Tuck O'Brien
City Planning Director, Planning Division

September 26, 2017

Project Name:	Liberty Bay Recovery Center	Project ID:	2017-086
Address:	343 Forest Avenue	CBL:	112-D004
Applicant:	Nathan Cermelj		
Planner:	Matthew Grooms

On September 25, 2017, the Planning Authority approved a Level II Site Plan application for site work to include reconfiguration and improvement of leased parking spaces on City property and the development of a patio area to the rear of the existing building at 343 Forest Avenue in the B-2b zone. The decision is based upon the application, documents and plans as submitted. The proposal was reviewed for conformance with the standards of Portland's Site Plan Ordinance.

Drawing file: CMP / CM-2 CONSTRUCTION MANAGEMENT PLAN.pdf

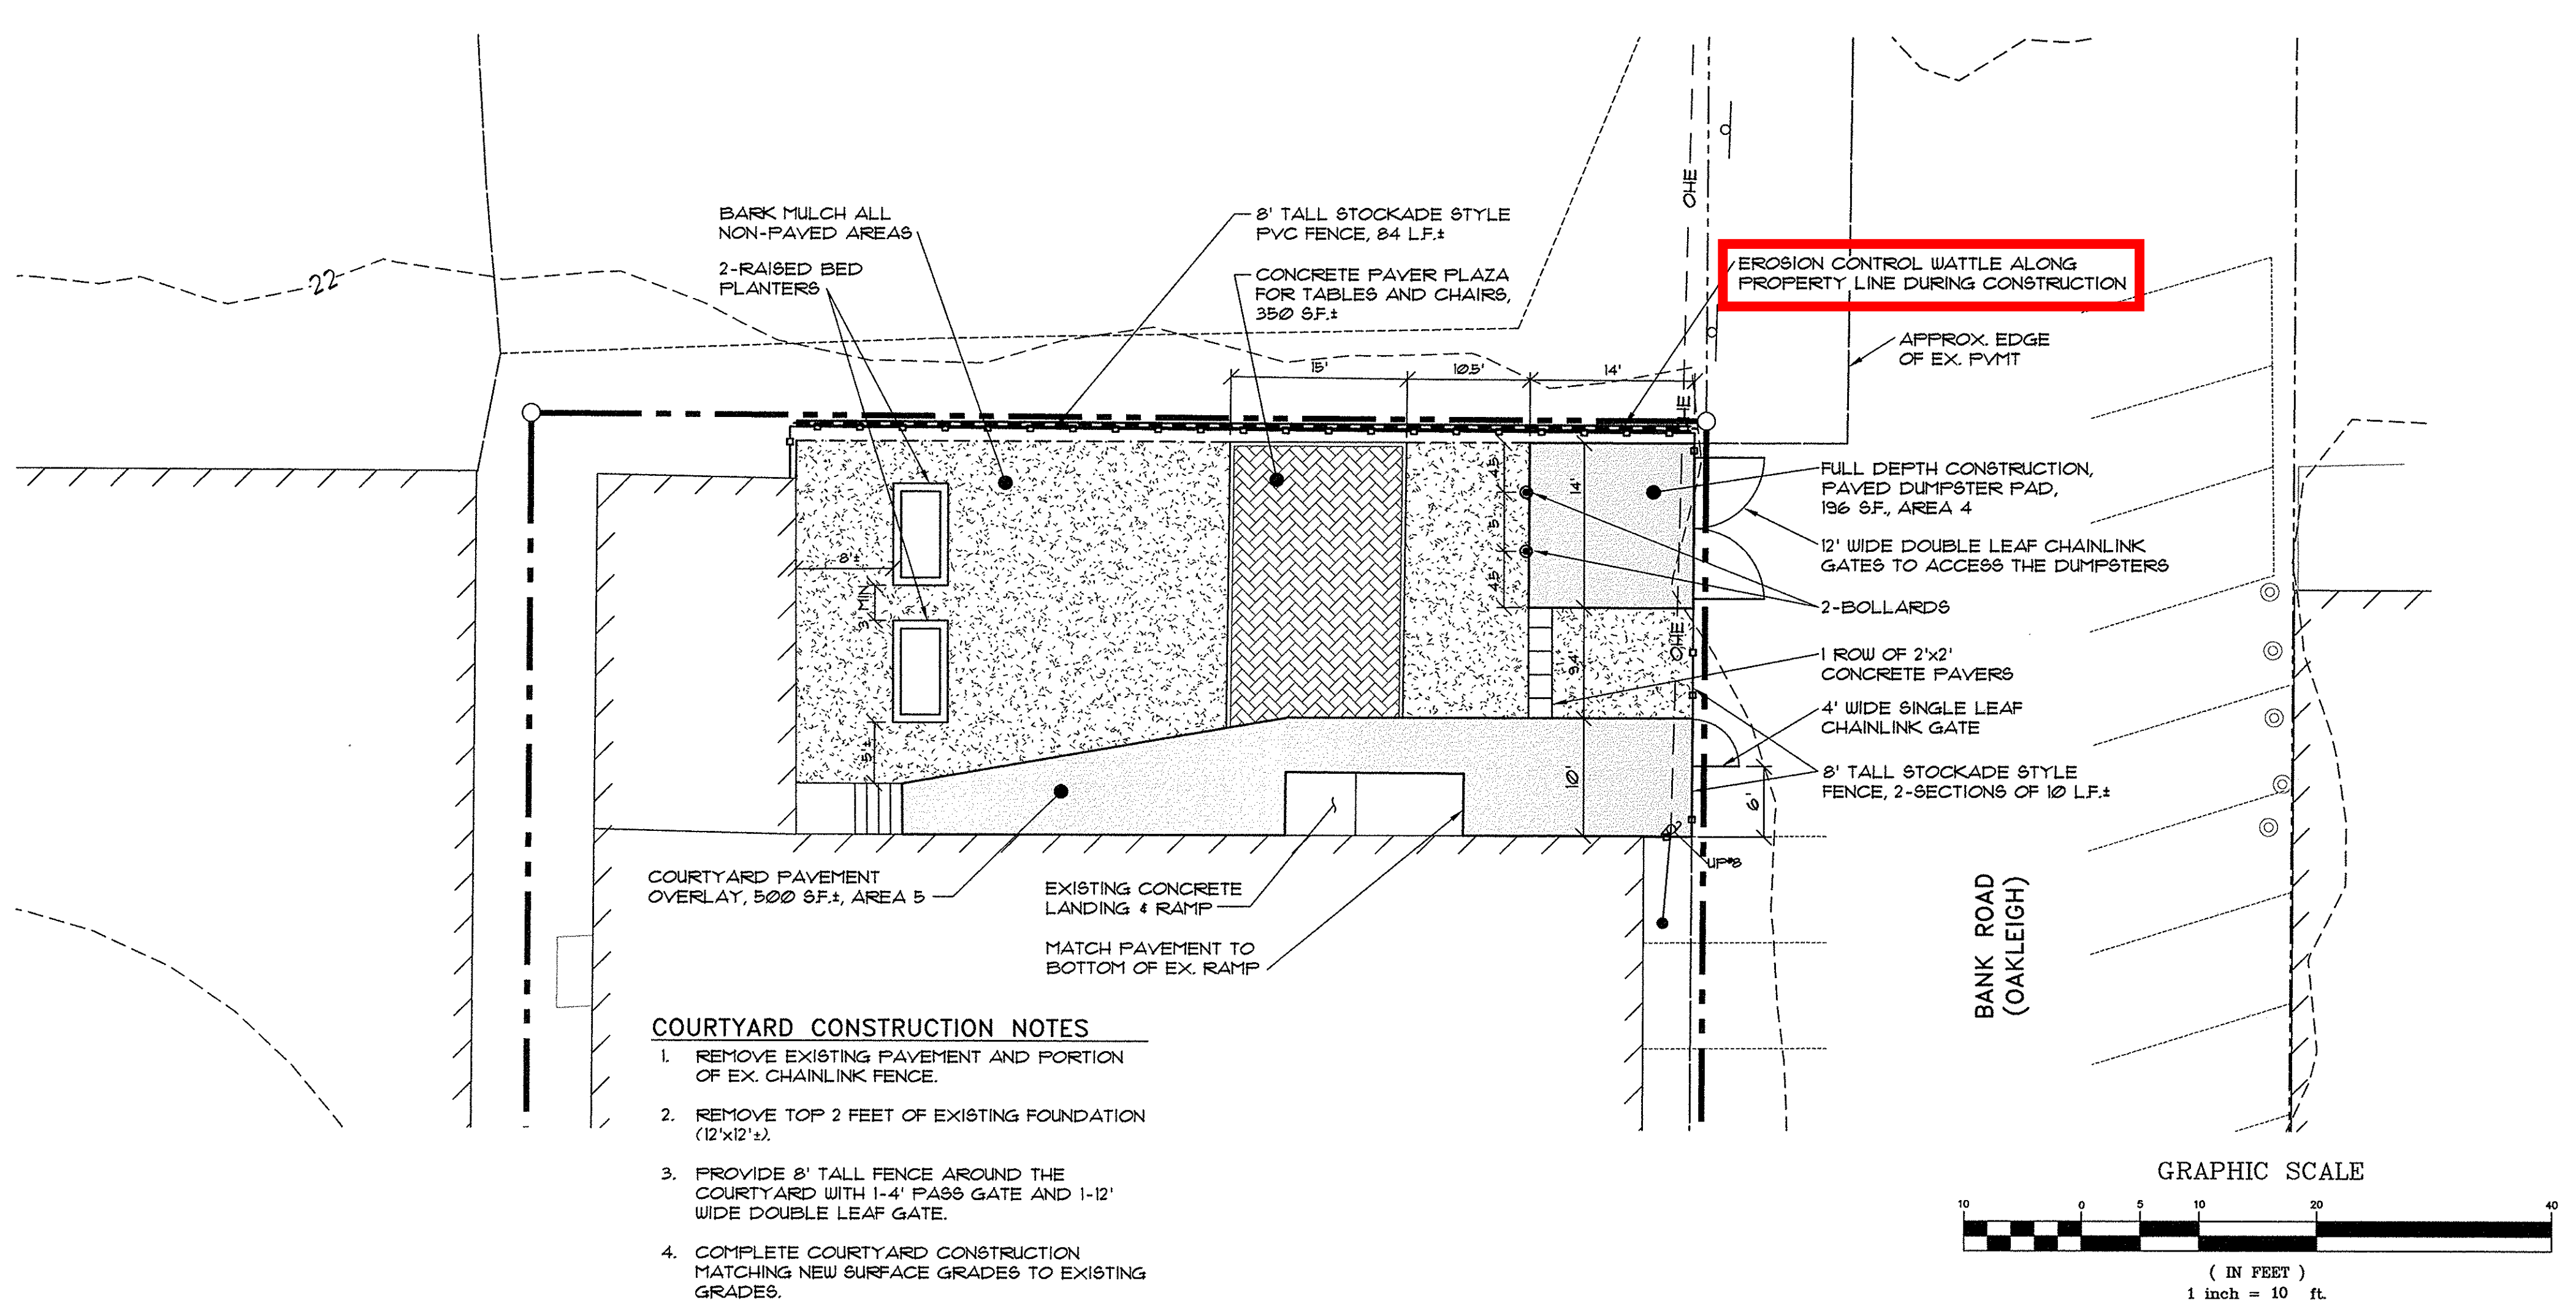
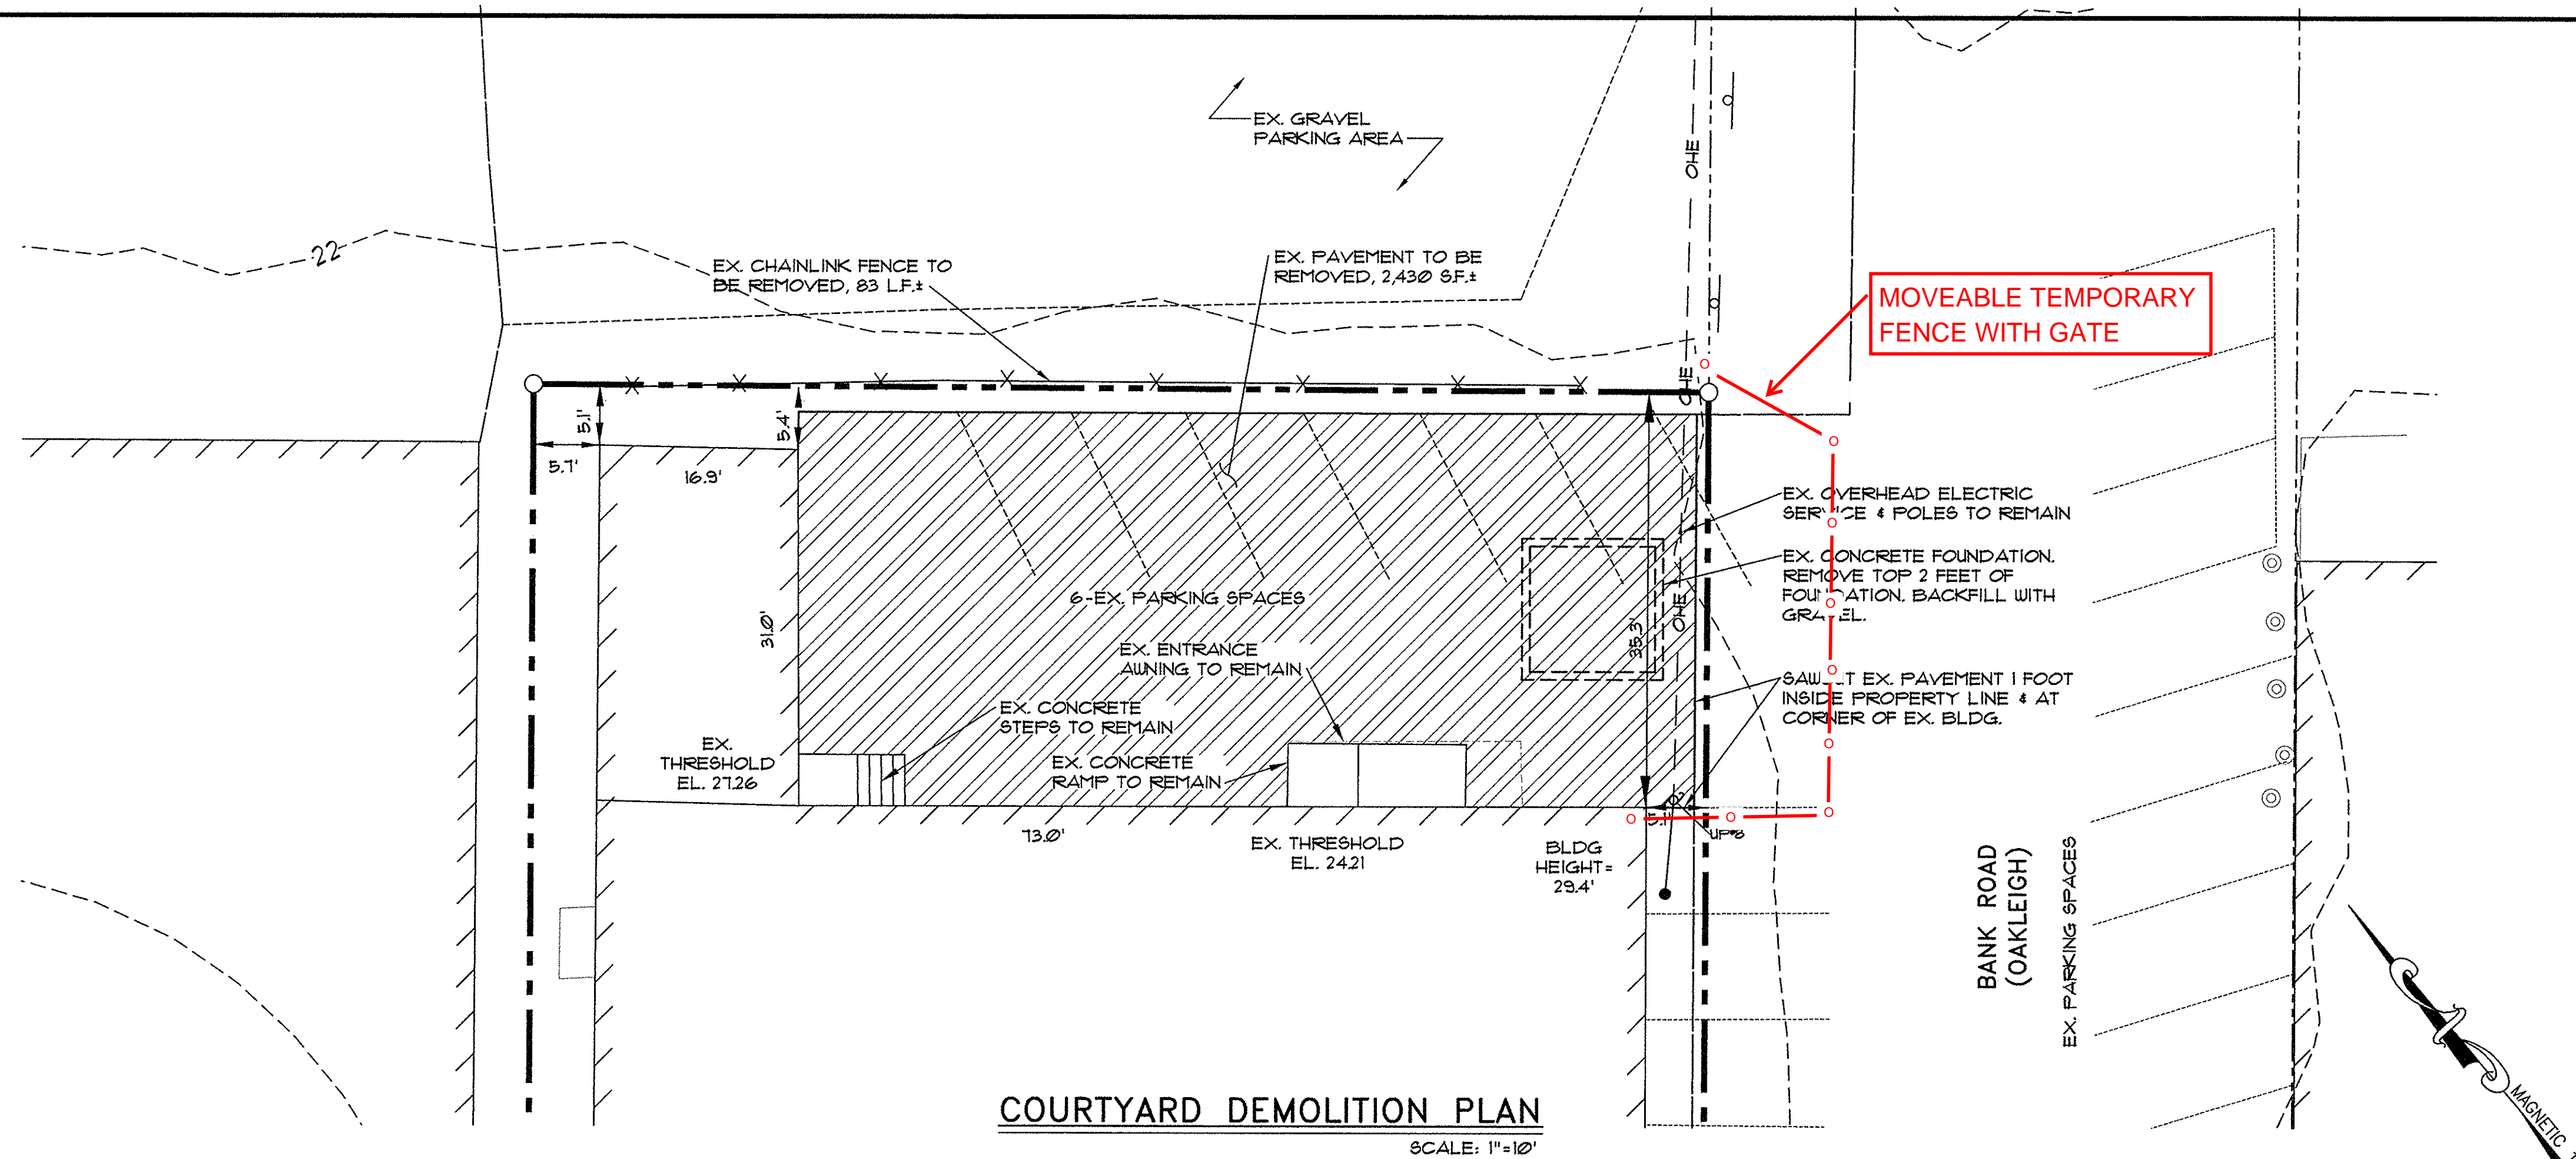
5. A revised construction management plan that conforms to the city's CMP template shall be submitted for review and approval by the Planning Authority and Department of Public Works.

- Provide a Construction Management Plan that includes: 1) a construction management site plan, 2) a construction schedule (time frame); and 3) a written narrative addressing the categories identified within the enclosed Draft Construction Management Plan General Template.
